DECISION DELEGATED TO HEAD OF PLANNING

Application No: H16-0319-26 **Applicant:** Blendly Hair Studio
Proposal: 2 Fascia Signs & 3 Barbers Poles - Retrospective
Location: 1 New Road Spalding Lincolnshire
Terminal Date: 15th June 2026

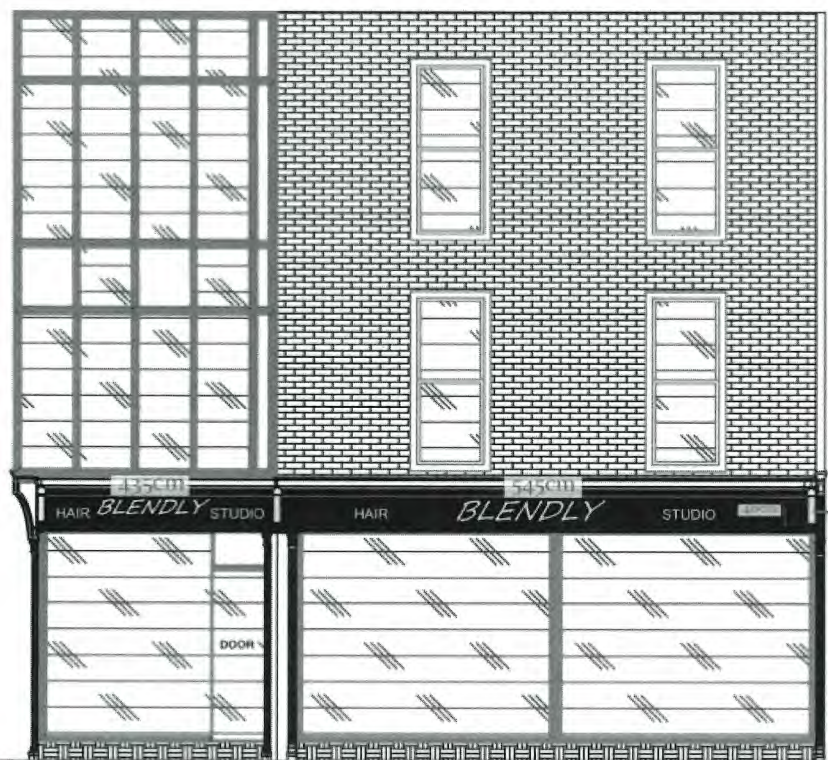
The design of the signage itself is relatively attractive and a definite improvement over the former signage on the property. However, the raised lettering utilises Internal or Halo illumination, which also upon visual inspection of the site, is lit in bright primary colours (at the time of the visit, the backlighting was bright green). In general, internal or halo illumination are not considered to be appropriate forms of shopfront lighting in a conservation area setting, particularly not for properties which retain a relatively traditional shopfront. This is exacerbated as an effect by the RGB colour capability of the proposed lighting which exaggerate the appearance of the proposal as being non-traditional and alien in appearance to the relatively traditional nature of sign lighting elsewhere in the conservation area.

The barber poles, whilst unique in their black and white design, are not inherently harmful, when considered in isolation of their illumination. When the illumination is considered, there is a fundamental conflict with the nature of the Conservation Area.

The use of internal illumination would fundamentally conflict with the Conservation Area. Its use is non-vernacular and detracts from the appearance of the area. The use of RGB colour further detracts from the appearance, being a unique and distinctly modern element which conflicts with the established historic character. This effect is exacerbated by the brightness proposed, which is in excess of the limited illuminated signage in the wider area.

The use of internal illumination, in particular illumination of varying colour, would inherently conflict with the Conservation Area. The proposal would therefore constitute less than substantial harm to the area, without any public benefit.
